From: Colin King [REDACTED]
Sent: 28 September 2020 21:28
To: Norfolk Boreas <NorfolkBoreas@planninginspectorate.gov.uk>
Subject: Norfolk Boreas Project EN010087.

REP15-006.

Applicant's Comments on Deadline 15 Submissions.
Regarding the Rochdale Envelope.

**APPENDIX 2: SLIDES SHOWING ONSHORE PROJECT SUBSTATION
INFRASTRUCTURE (AGENDA ITEM 4 (b) I)**

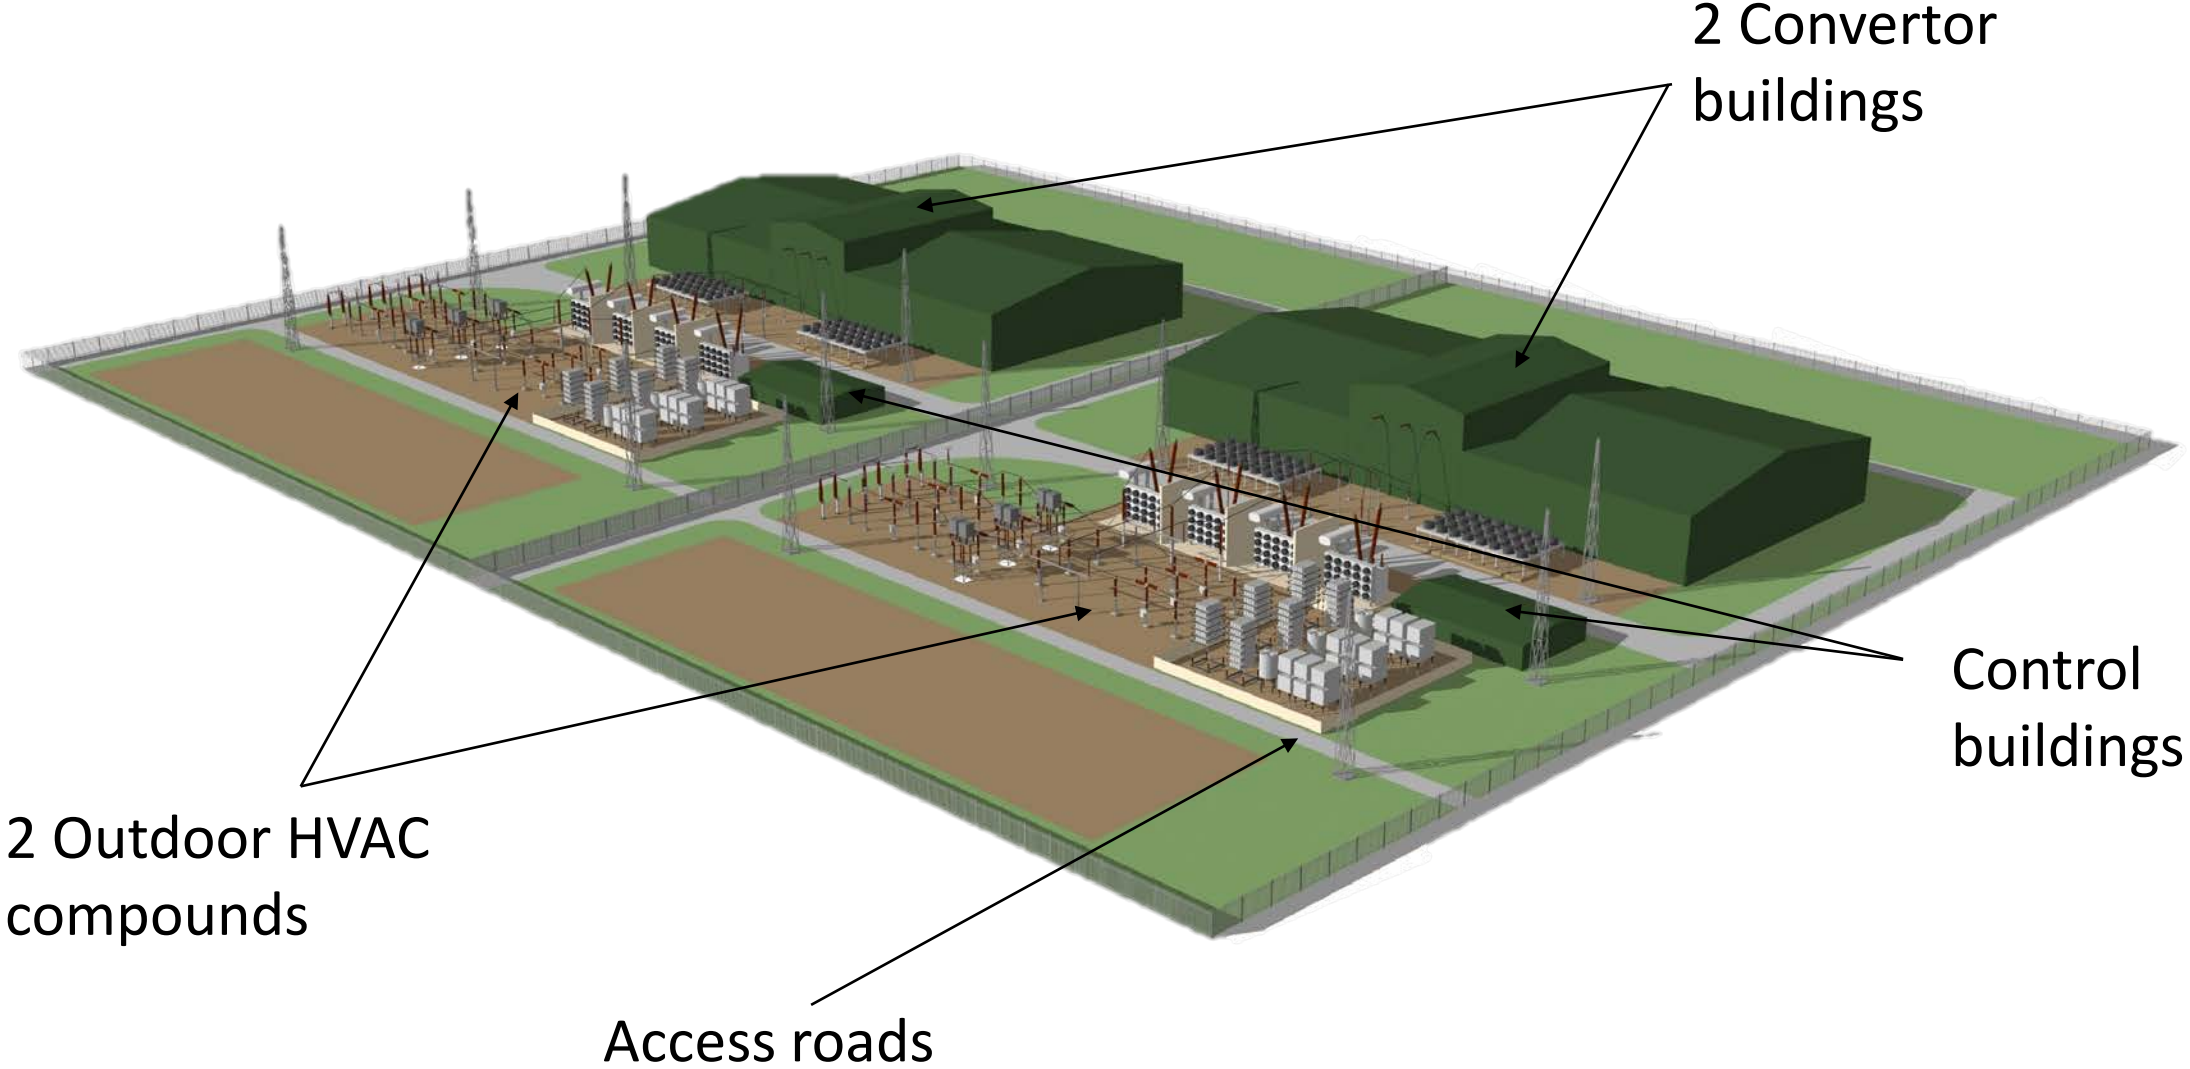
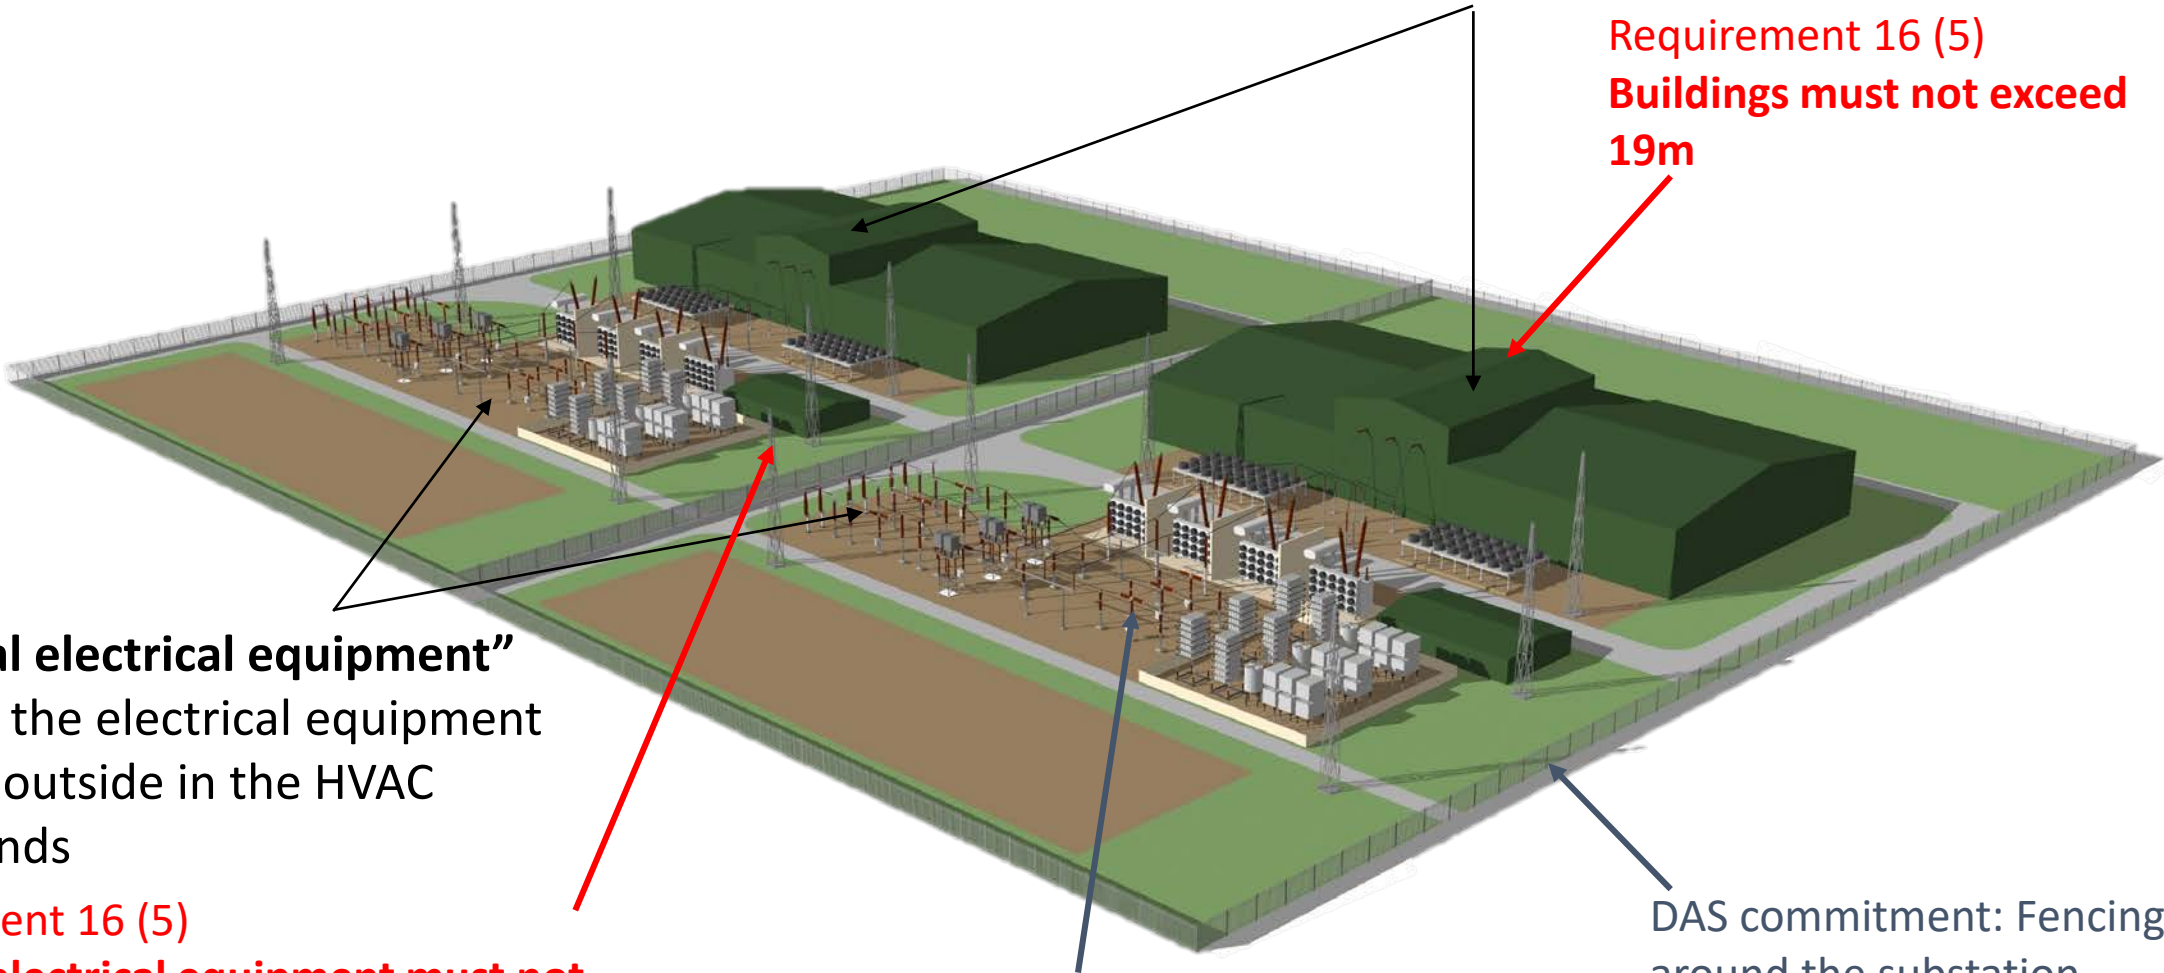
Firstly I agree with the applicant's explanation, that the ceiling of the blue dotted box is set at 25m and the converter halls' fronts are 19m, which gave me the impression that the halls' fronts were set on the site's back line. My mistake, and I apologise.

I find it unclear that the applicant explains, **"A 3D model of the onshore substation has been used to give an indication of what the substation will look like and a blue dotted box represents the Rochdale envelope, within which the substation elements can move. By showing the blue Rochdale envelope alone, we may overestimate the extents to which the development could be visible. By showing just the substation model alone, we may underestimate visibility. Hence, the use of both techniques in the visualisations." (from comments on relevant representations page 153, table 24 no4,)**

And they also explain, **"The visualisations show the worst case assumptions and further design iterations post consent will either maintain those levels and extent of visibility, or reduce them."**

**APPENDIX 3: OS MAP SHOWING CHANGE IN LEVELS VP3 (AGENDA ITEM
4 (a) II)**

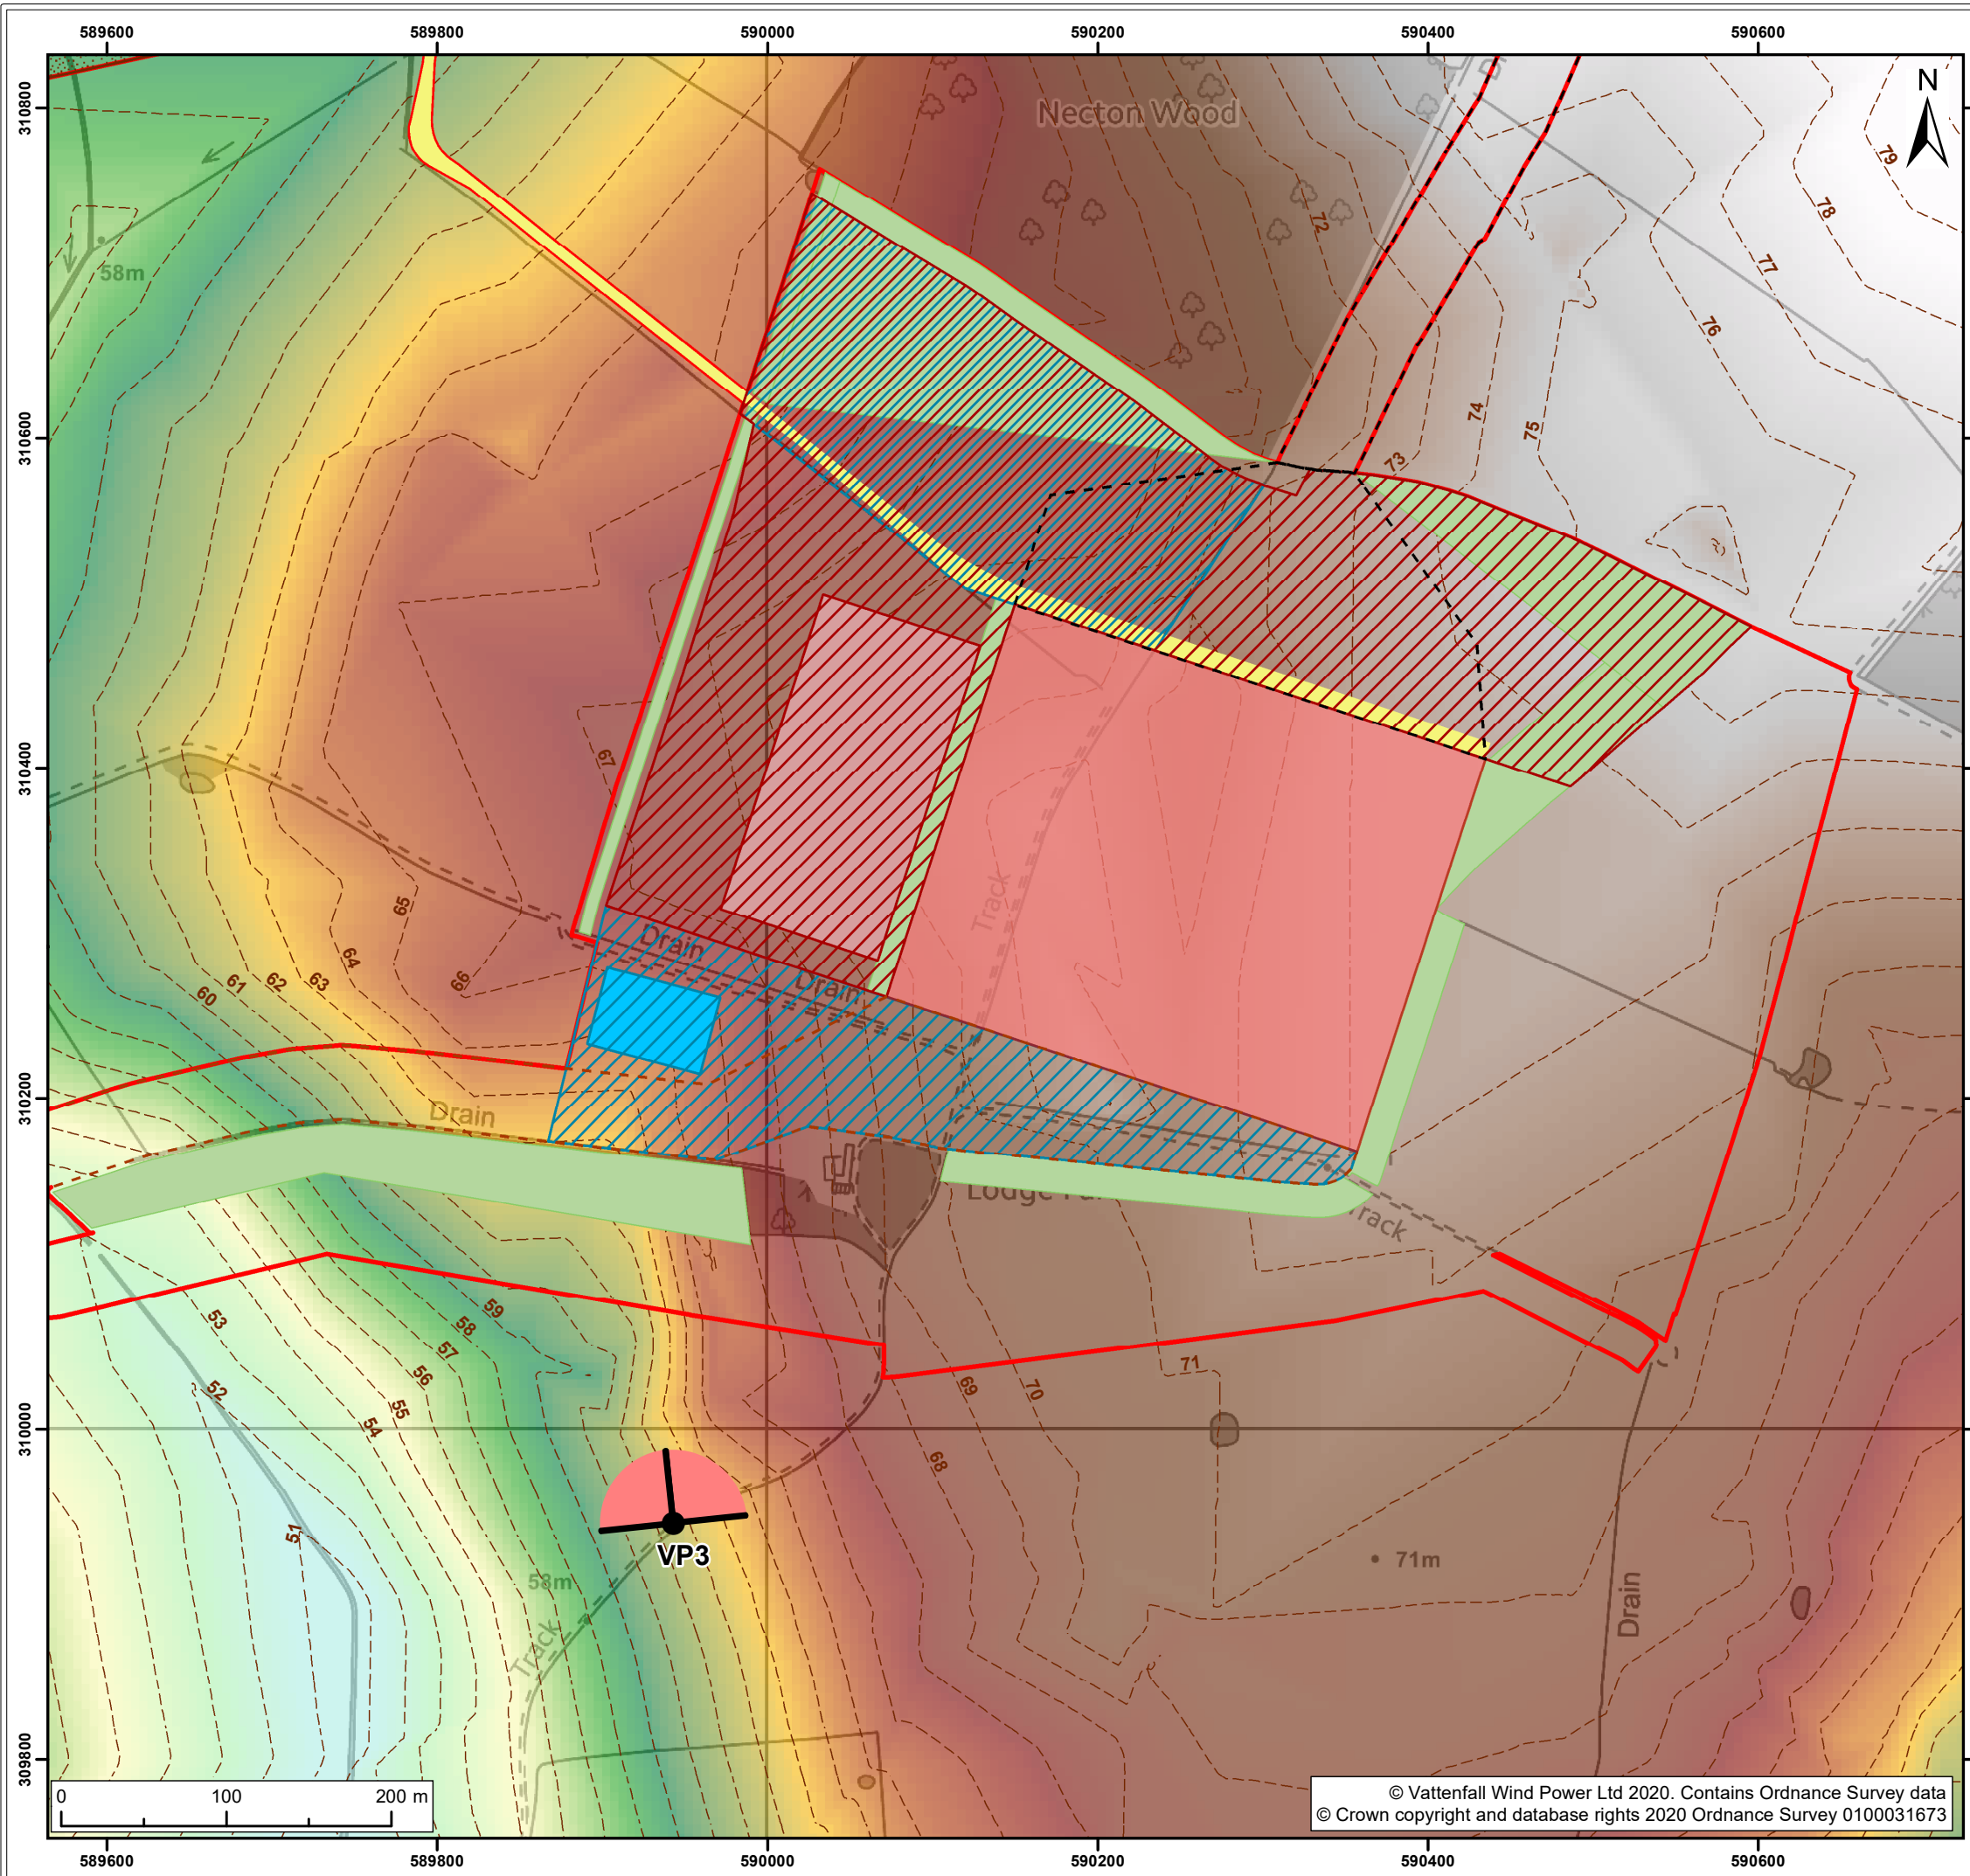
2. Viewpoint 3 shows the same issue to a lesser extent as viewpoint 2.
